Ref: DD_17_217_1528

Submissions to Lamberts Gully and Angus Place Extension Applications

Centennial Coal
Proposed Angus Place Colliery Extension
Response to Submissions
March 2006

Centennial Coal
Proposed Lamberts Gully Extension
Response to Submissions
March 2006

FIGURE 5
Lamberts Gully - Water Management Plan

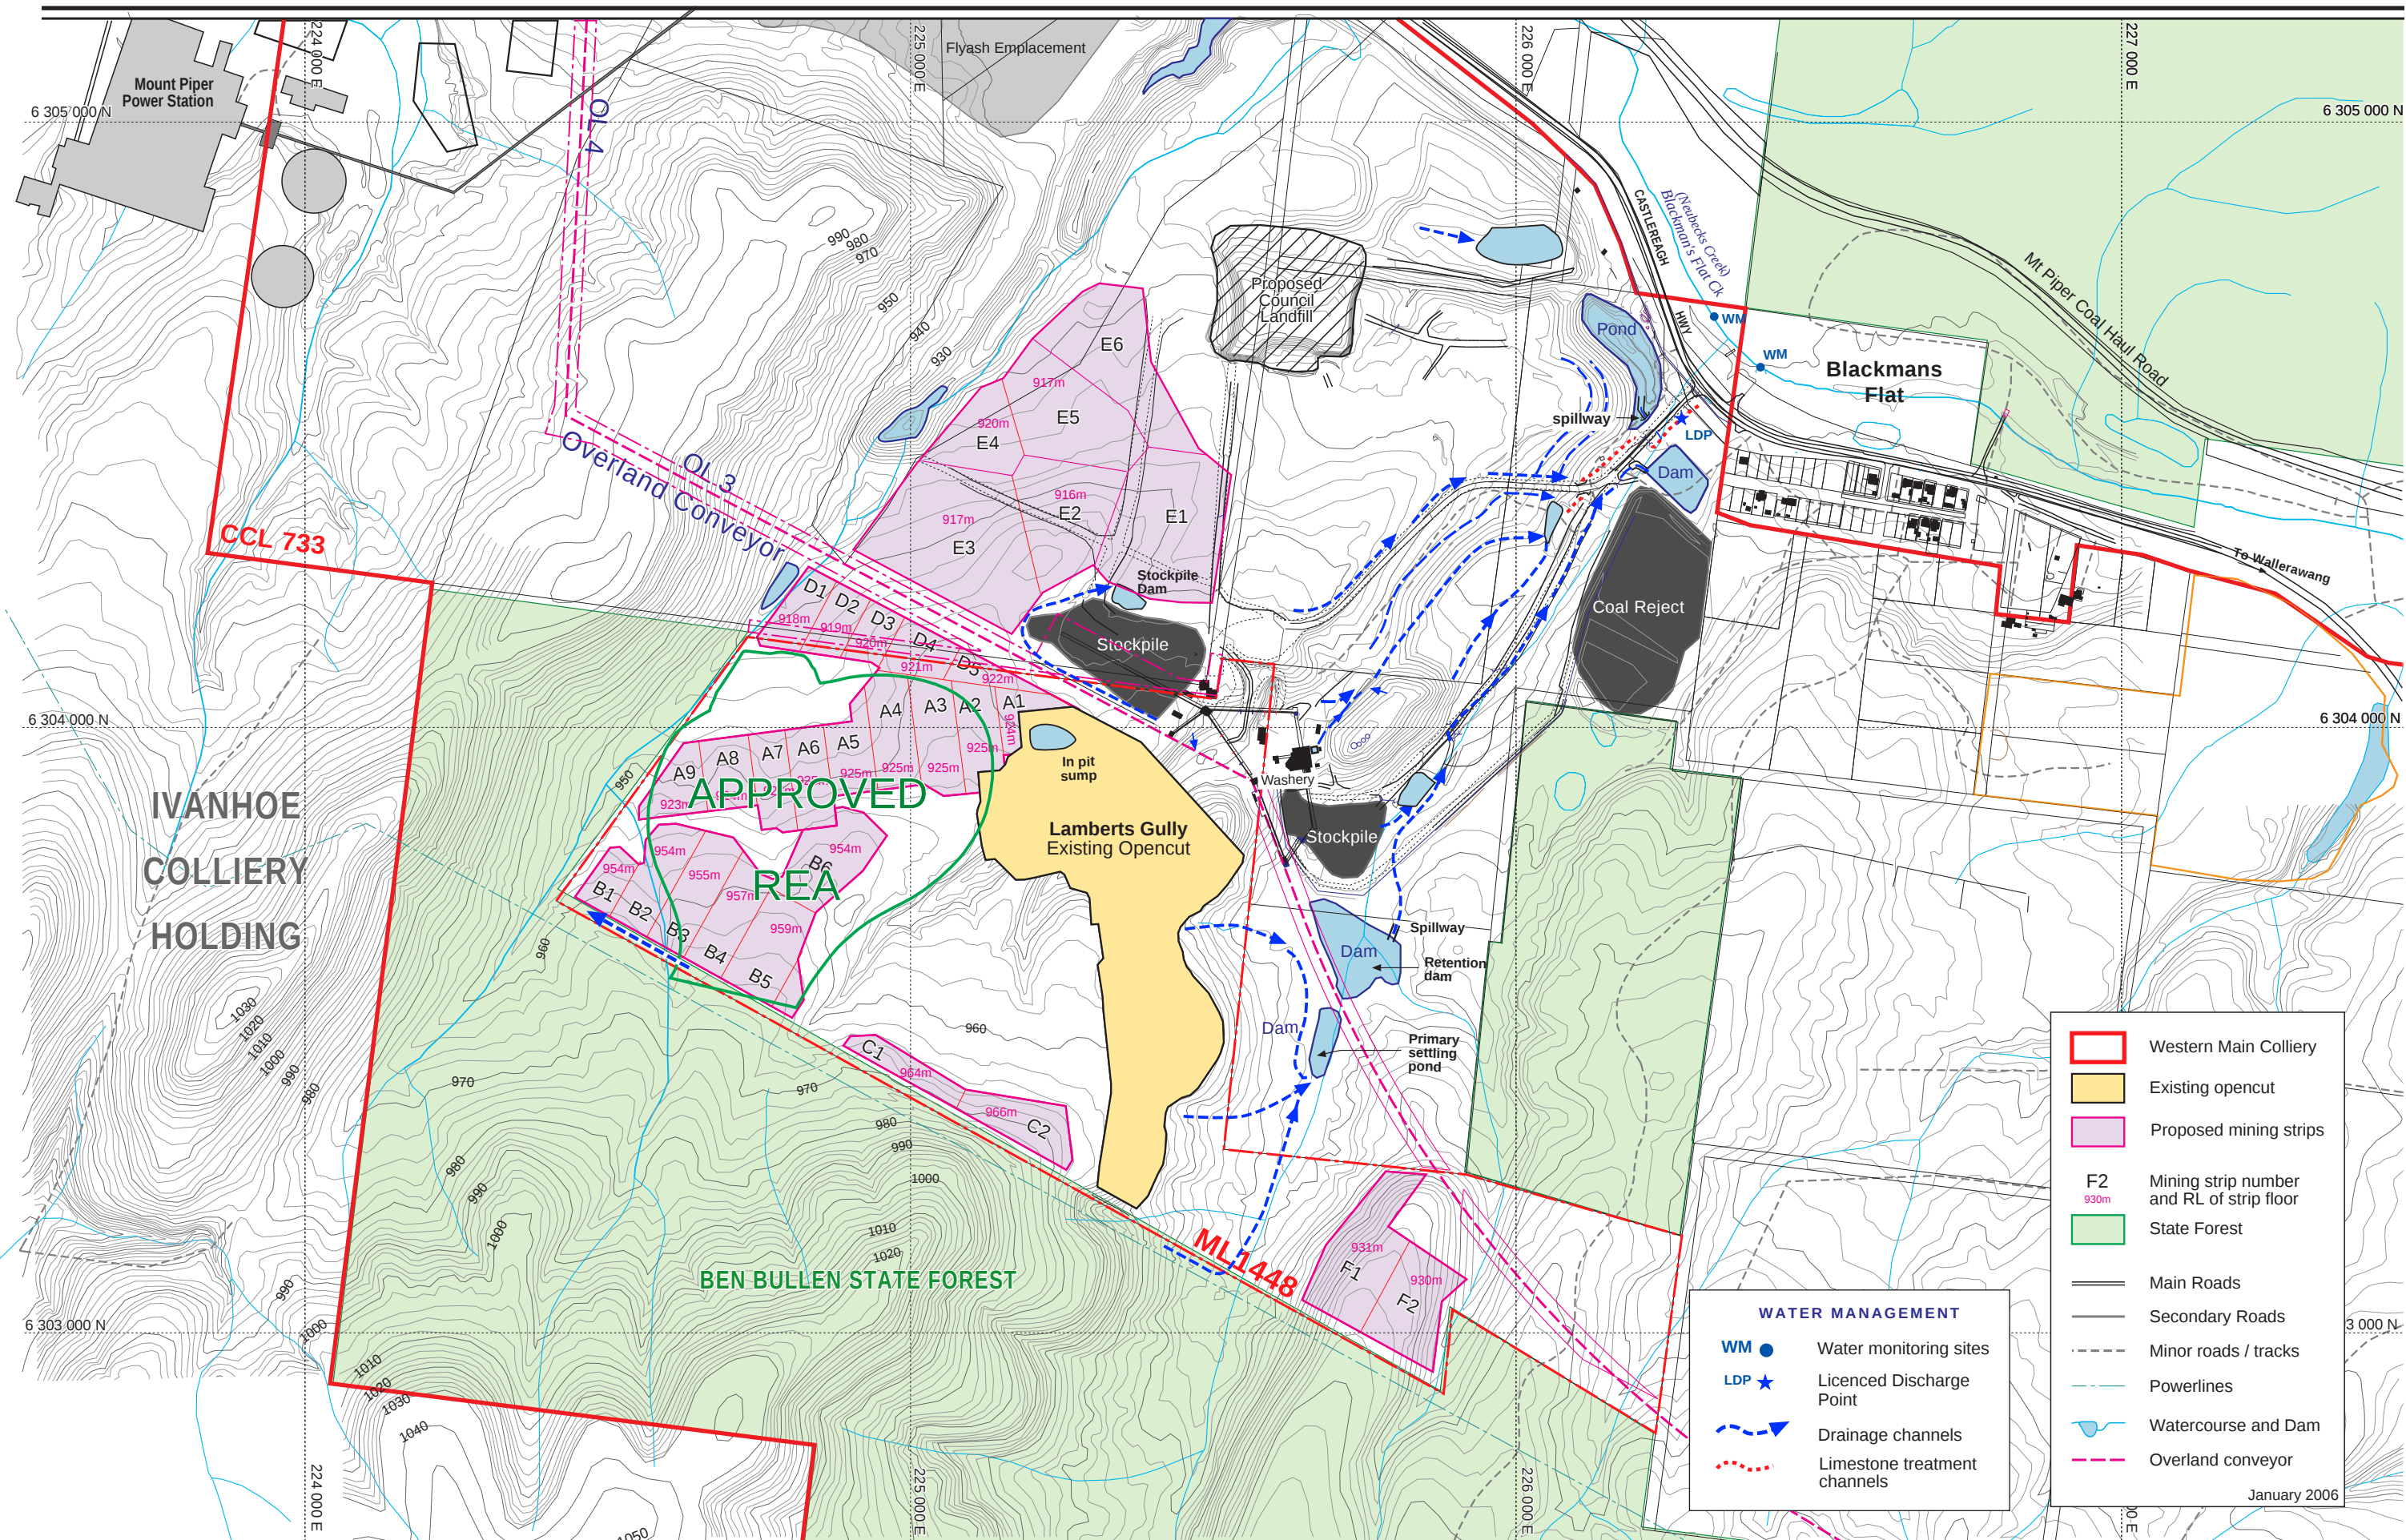
Response:	A MOP will be lodged prior to mining in those areas not currently covered by a MOP.
Issue:	<i>Reject Emplacement Areas</i>
Response:	Appropriate applications under s126 will be made by the Mine prior to the emplacement of reject material within the REA.
Issue:	<i>Drainage System – catchment capacity</i>

Response:	There is only a very small area of clean catchment above the future mine area. Wherever practical clean water will be adequately diverted from entering the working area. Although there is an increase in dirty water catchment, there will be no additional stormwater loading entering the pollution control system. As described in Section 7.1.1, the extension will operate in the same manner as the existing open cut and retain stormwater in inlet sumps. This water is used for dust suppression and on site water demand.
Issue:	<i>Topsoil Management</i>
